Your Ref: OWPC25515
Our Ref: LU/341/19/PL 08-11-2019
Please ask for:
Andrew Wood

Combining two adjoining flats & alteration to glazing.

37 & 43 Beach Crescent Littlehampton

Proposed South Elevation NTS

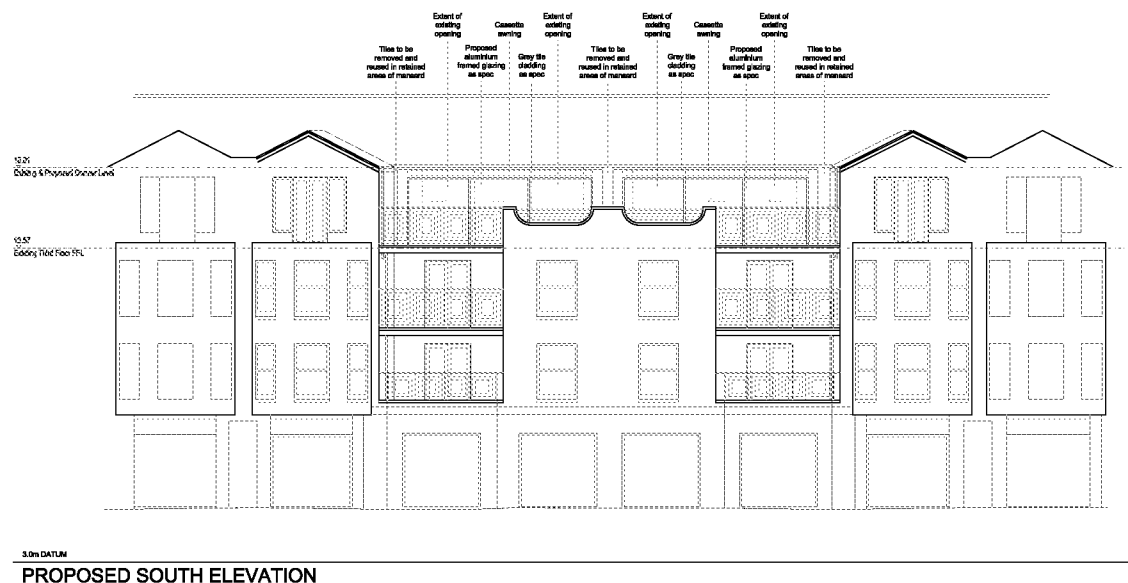
Viewing the proposed external design for the southern elevation it seems to be detrimental to the carefully thought out design given permission originally. The view of those looking towards the site from the seafront green and promenade is just as important as the view from the residence itself. This will just draw the eye towards a penthouse. The loss of a residential unit is something Arun District can ill afford given the current land supply situation.
